Response to WSCC Strategic Planning Consultation Comments dated 30 November 2012

Proposed housing development at

Roundstone Lane, Angmering
Arun Planning Application A/82/12

12 December 2012

Appendix 1
Junction Dimensions Drawings

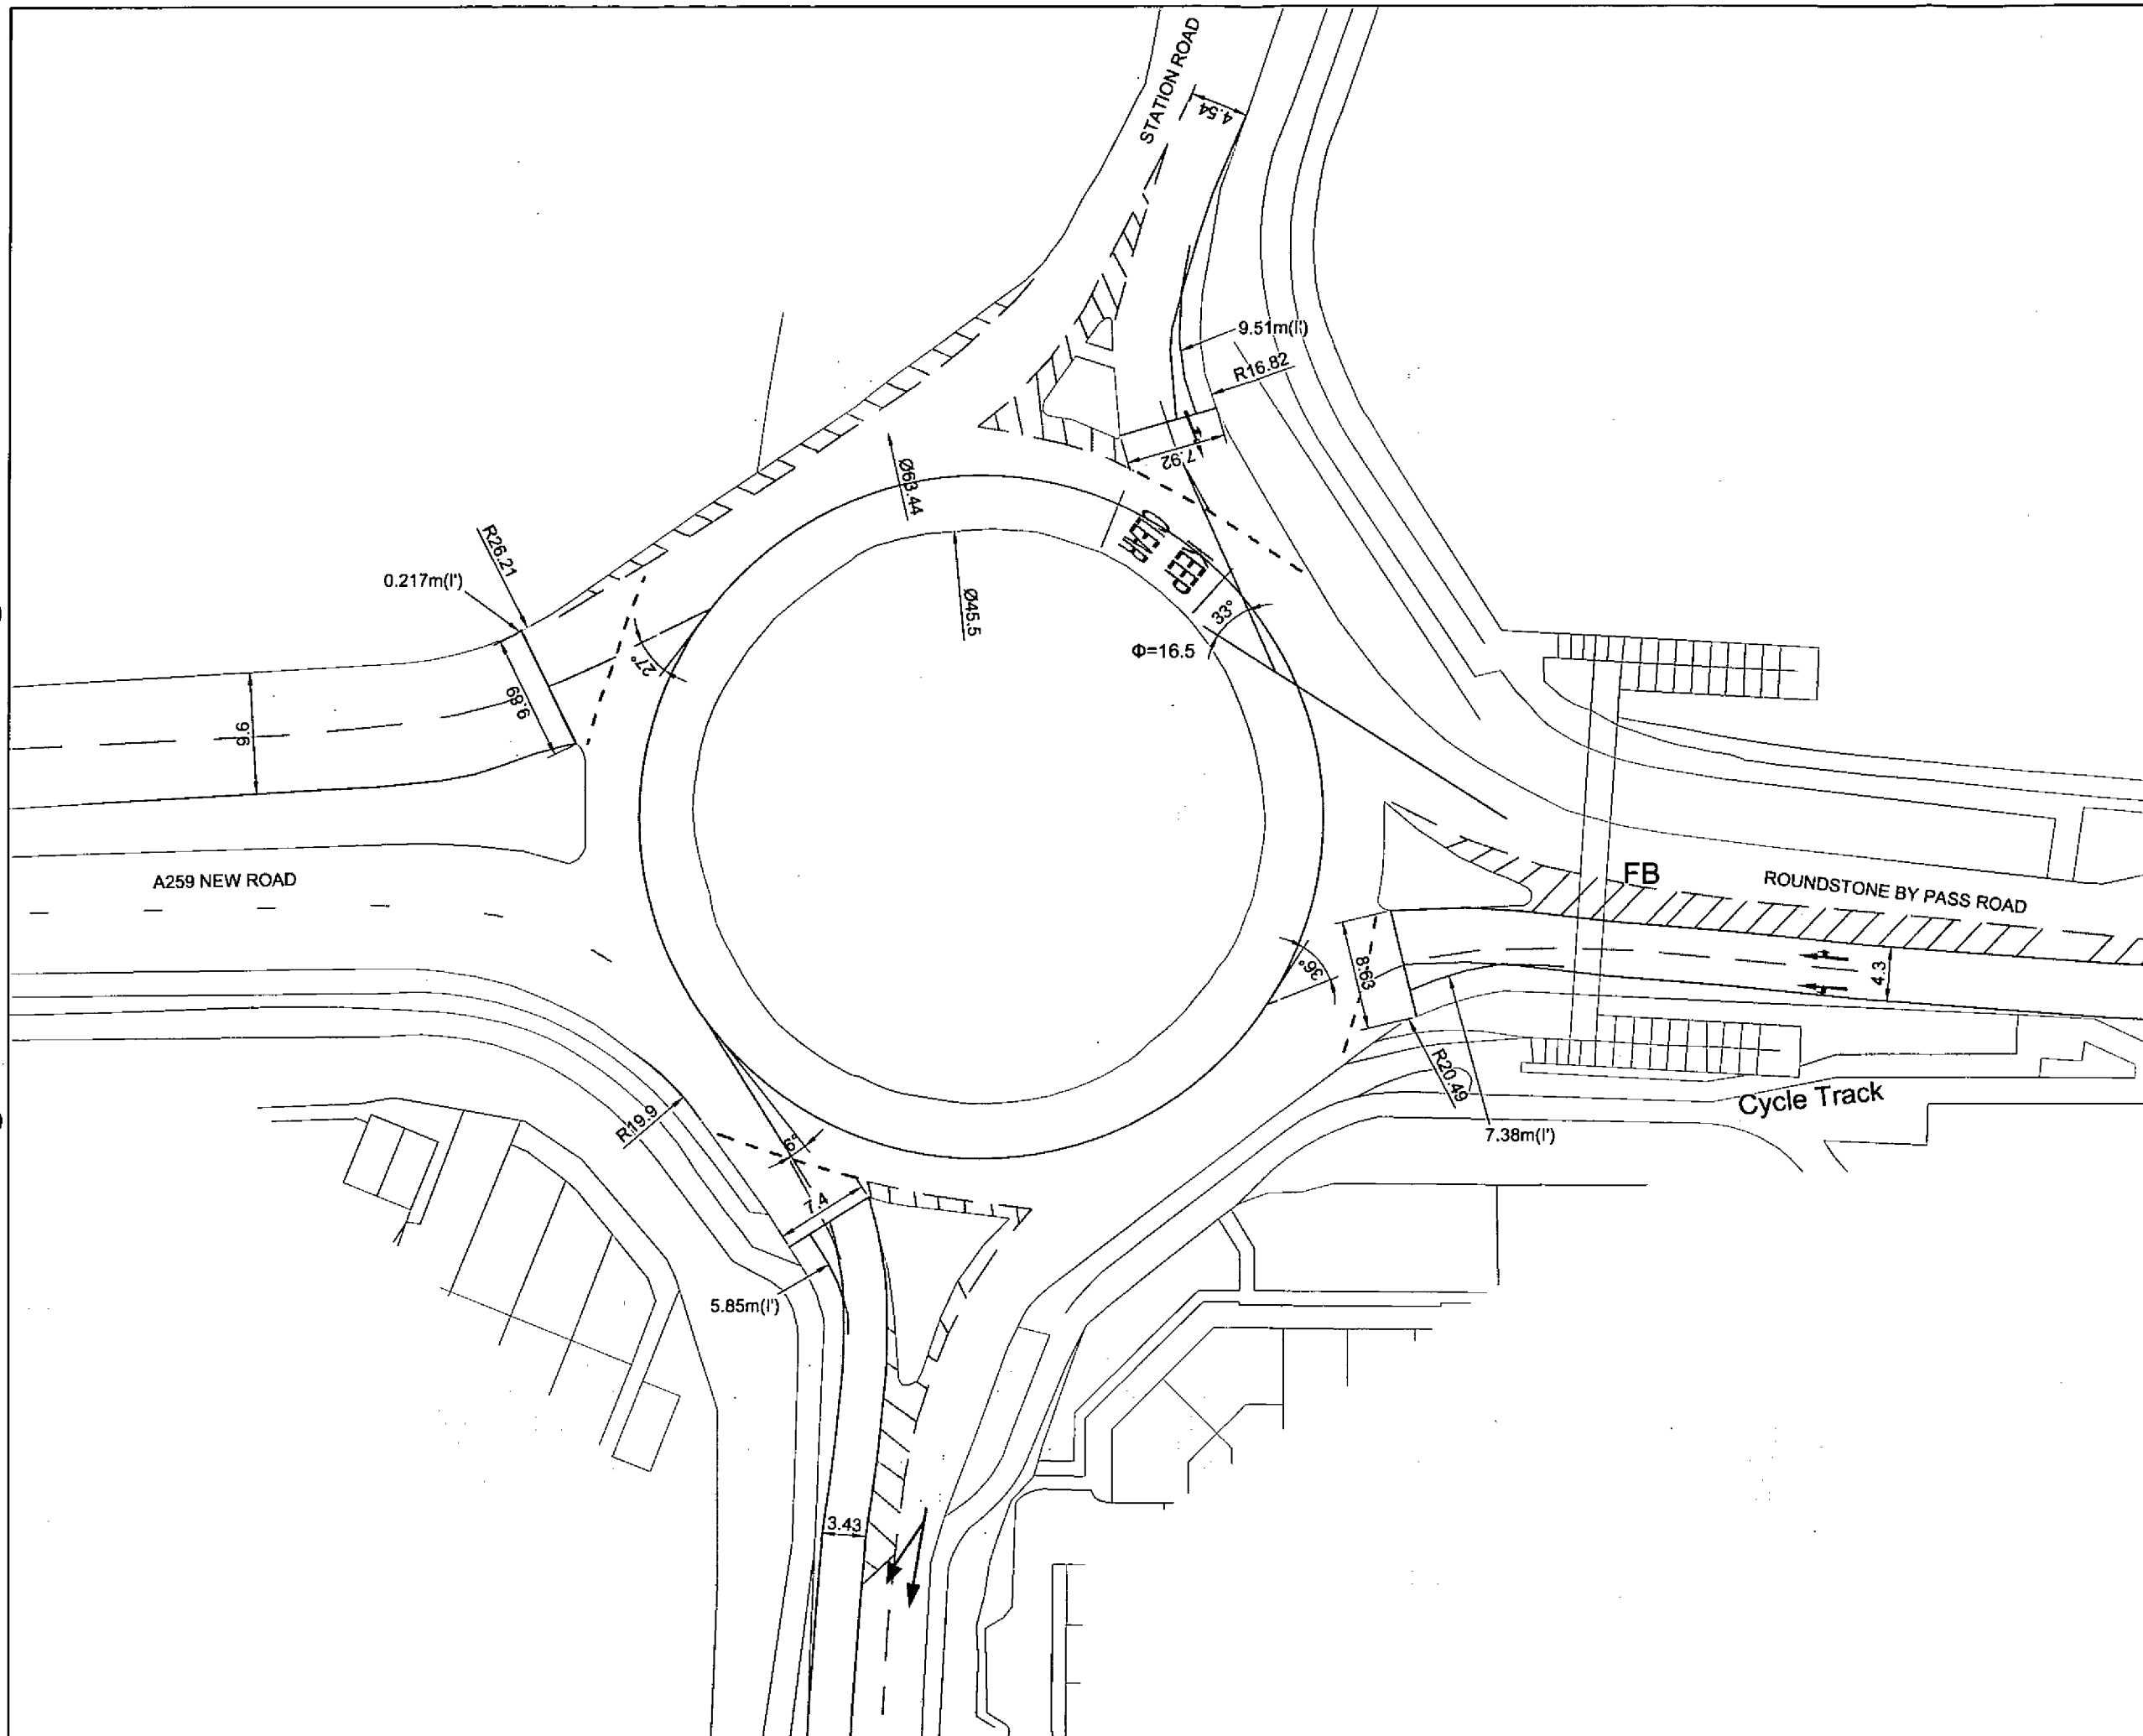
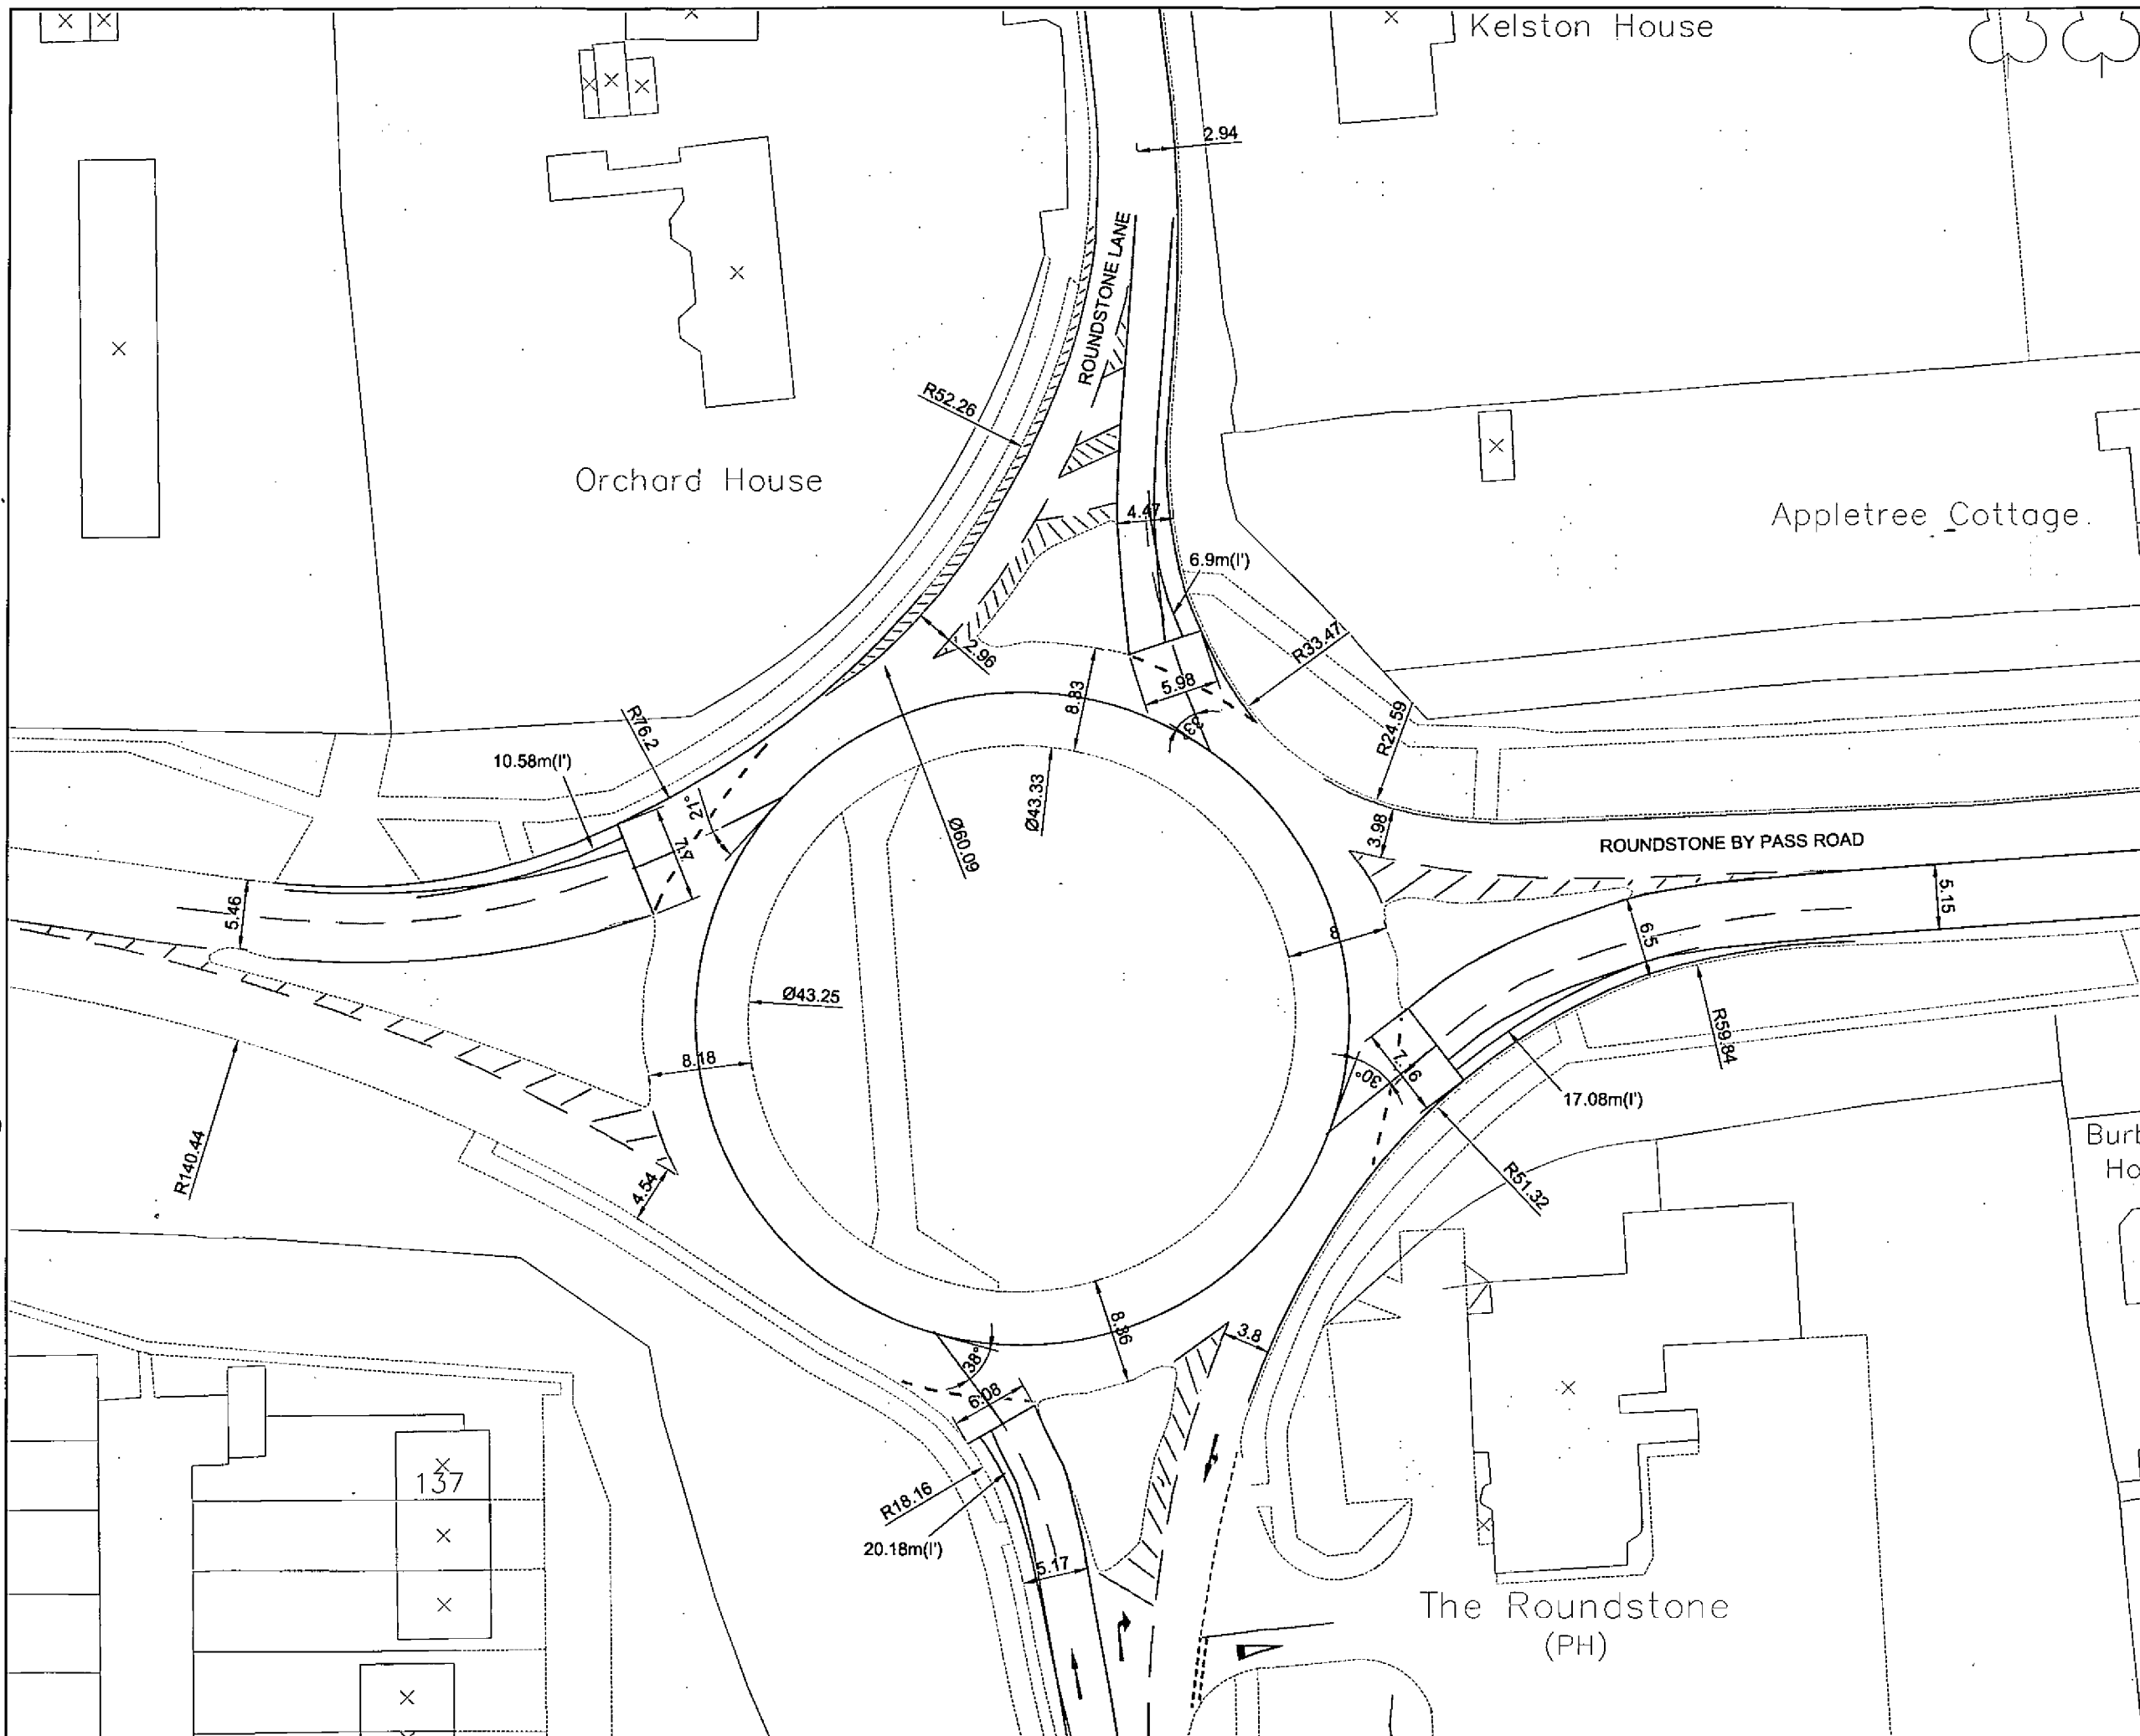
All input geometry has been rechecked and minor alteration made to the models where necessary. Drawings 22067/112 – 118 highlighting the input geometry used to analyse the Roundabouts and T junctions are attached in Appendix 1.
